Colorado Geological Survey comments for:
EP-24-0080 Crystal Park Site S-122 (AR) Site Plan
NW¼ NE¼ Section 18, T14S, R67W, 6th Meridian
38.8385, -104.9308

The referral documents included the Site Plan (LGA Studios, 9/5/2024), Geologic Hazard Study (Rocky Mountain Group (RMG), 5/17/2024), and Soils Report (A Better Soil Solution, 9/7/2023) for the proposed residence at 6881 Eagle Mountain Road.

SITE PLAN  
 VICINITY MAP  
 SITE NOTES

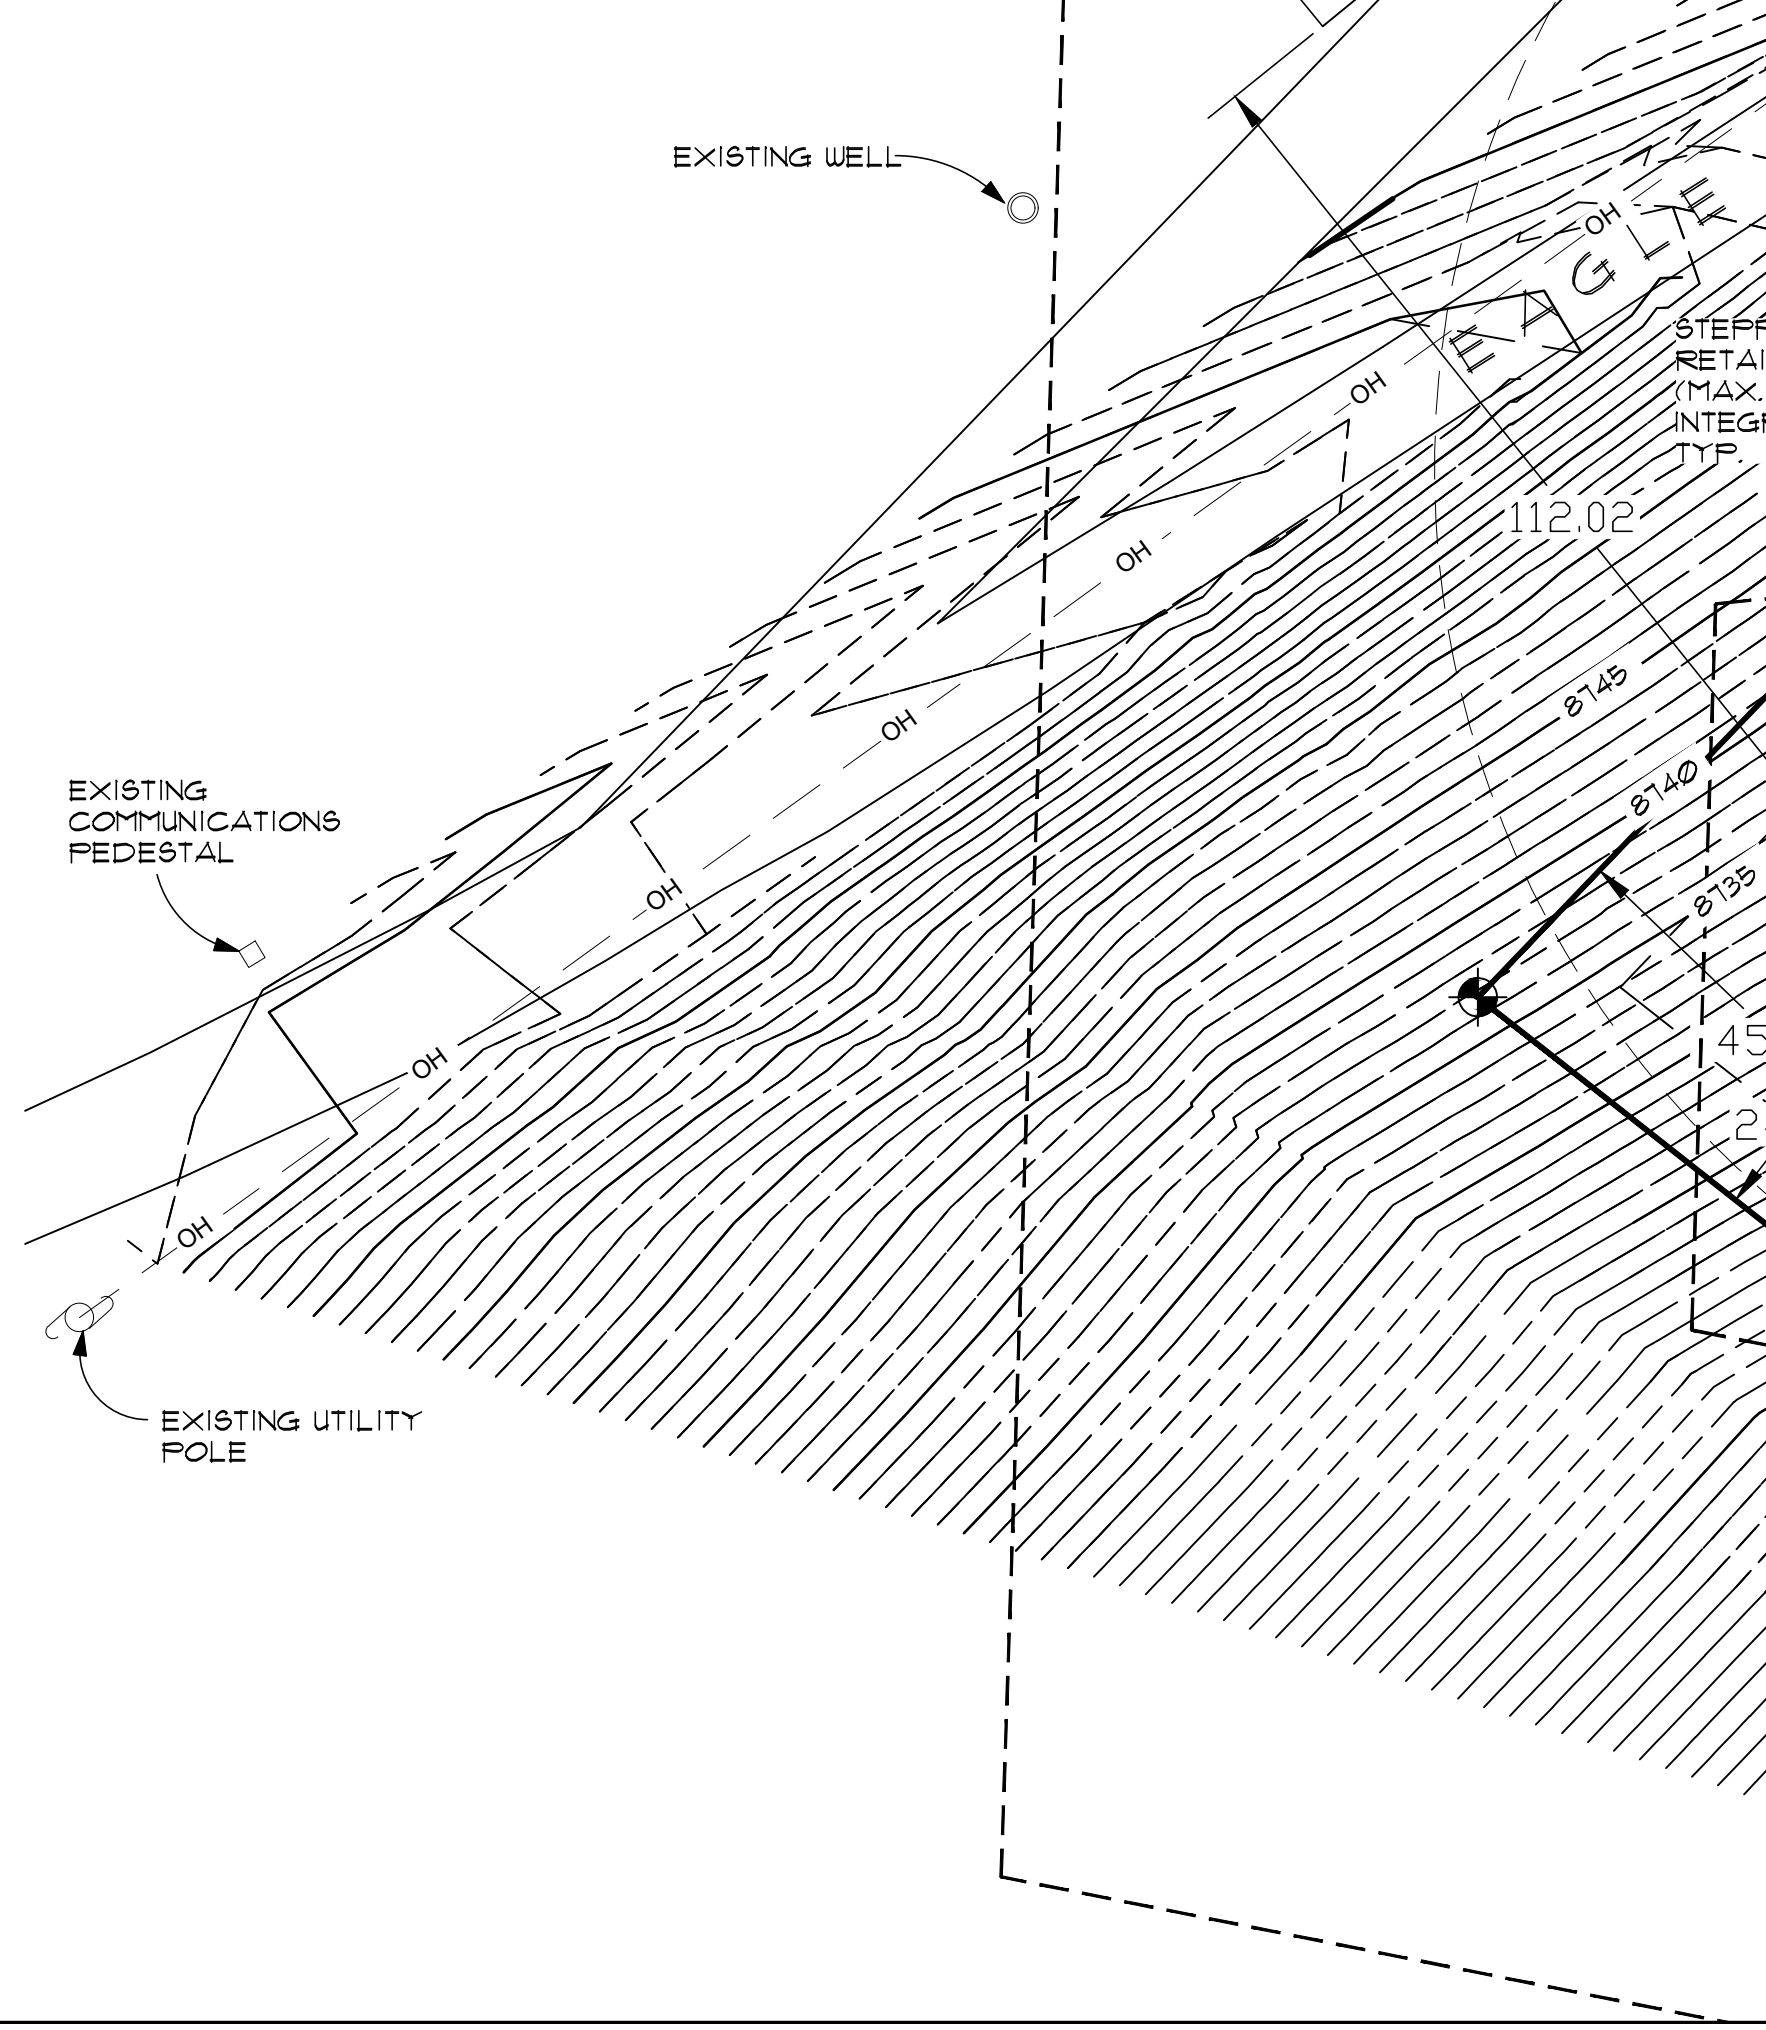
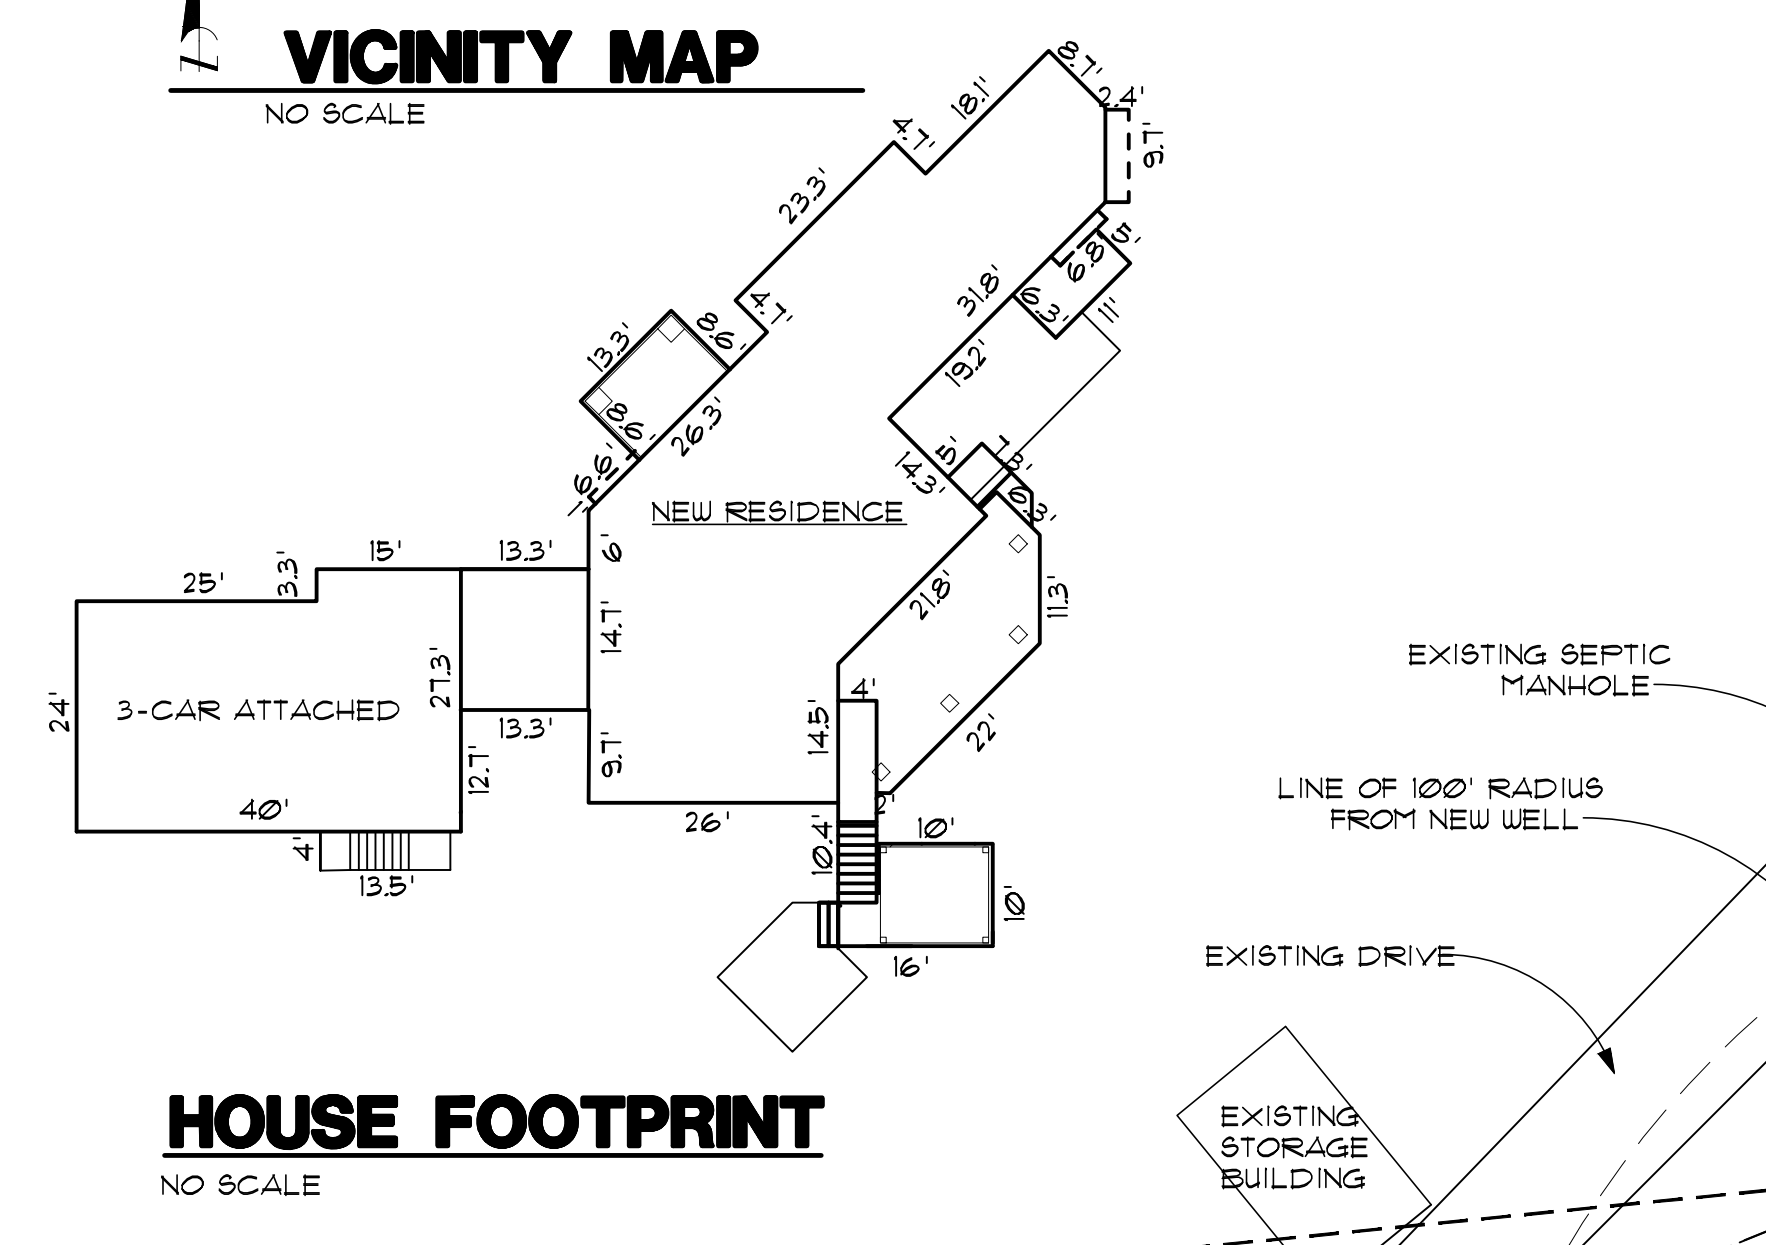
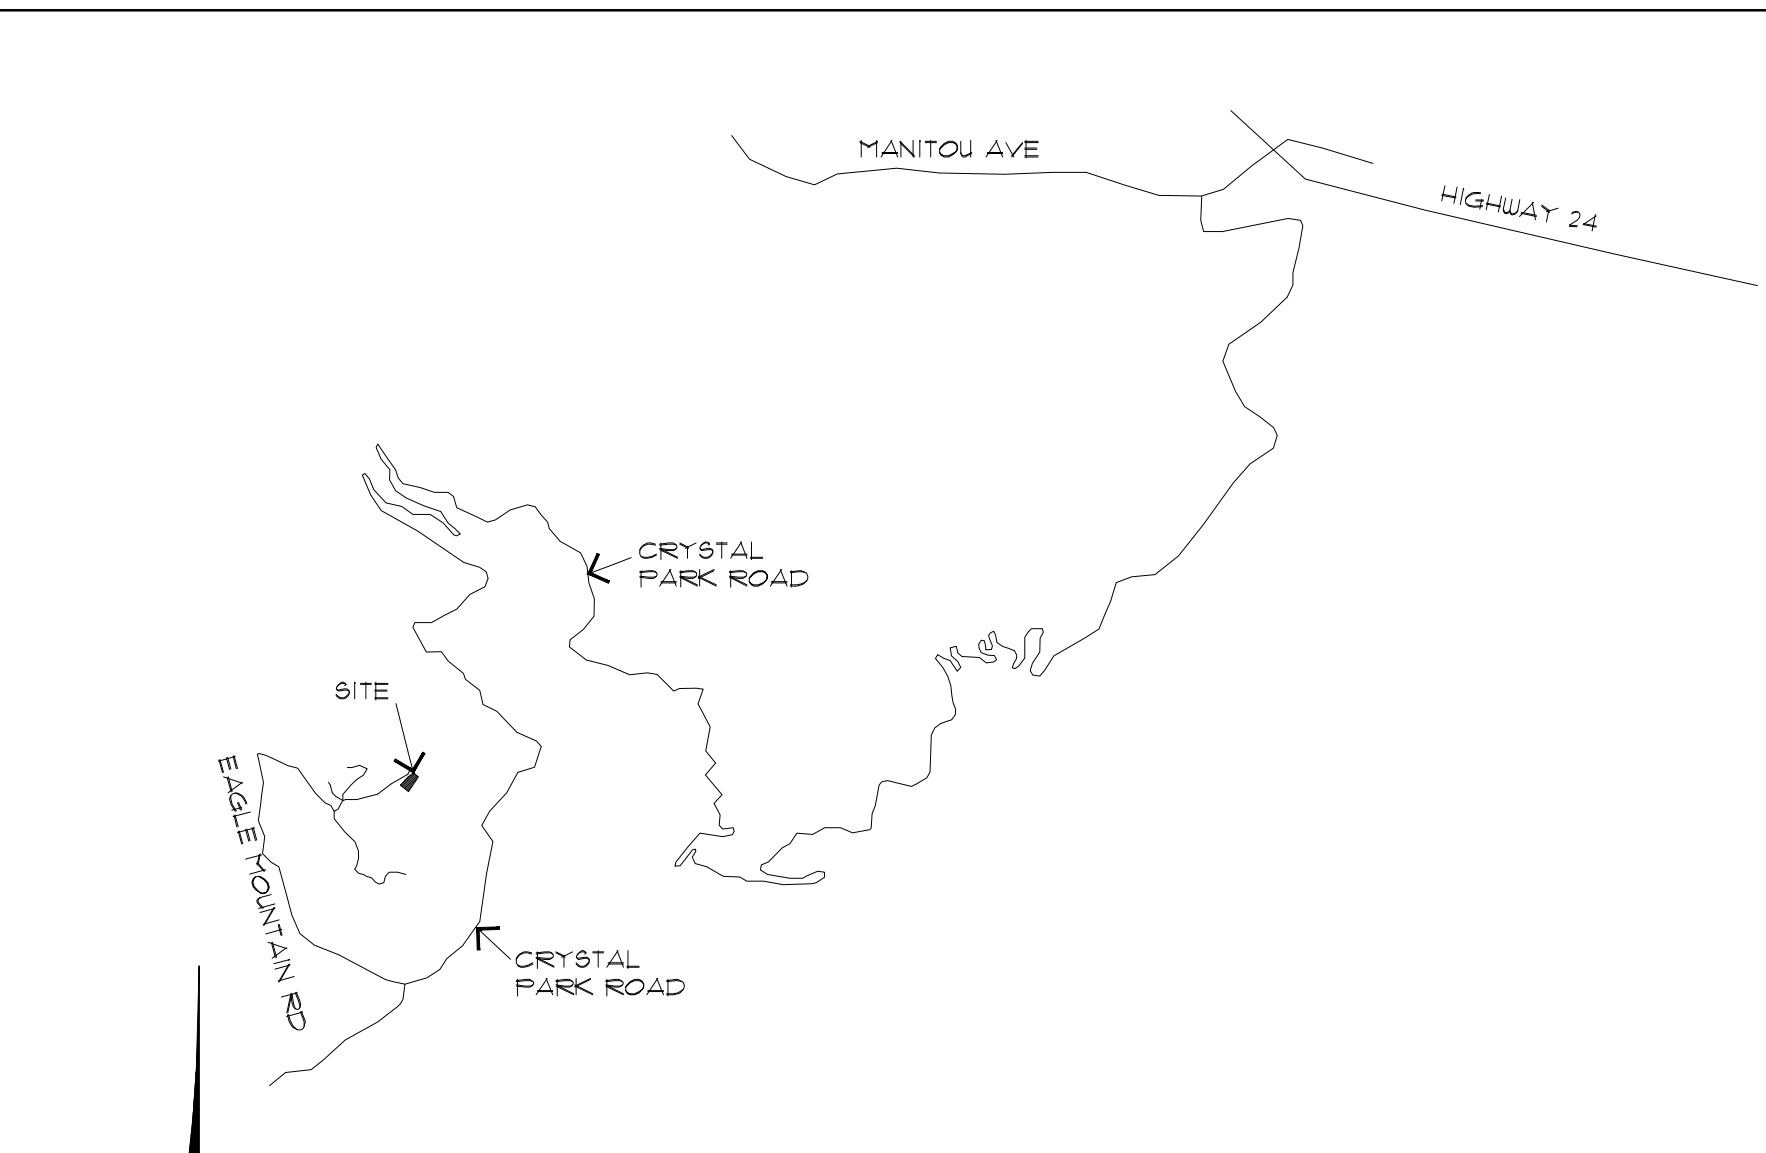
Site S-122 does not contain rockfall hazards or mapped landslides but does contain steep slopes, up to 60 to 70 percent descending south and east, and 1041 hazard mapping describes these slopes as potentially unstable to unstable. Based on the site plan showing existing grades, it appears that the proposed residential structure will be located within the flatter area of the site (about 5 to 10 percent).

3. CGS recommends that all planned cuts exceeding *four feet* in height be evaluated for slope stability using proposed slope geometry and considering all foundation and proposed cuts that will affect the slope. The geotechnical engineer should be provided with the construction plans and grading information to verify the proposed slopes.

5. The site plan indicates a leach field (septic location) is planned northeast of the proposed residence. Engineered septic systems are commonly used in the Crystal Park area due to the steep slopes and geology.
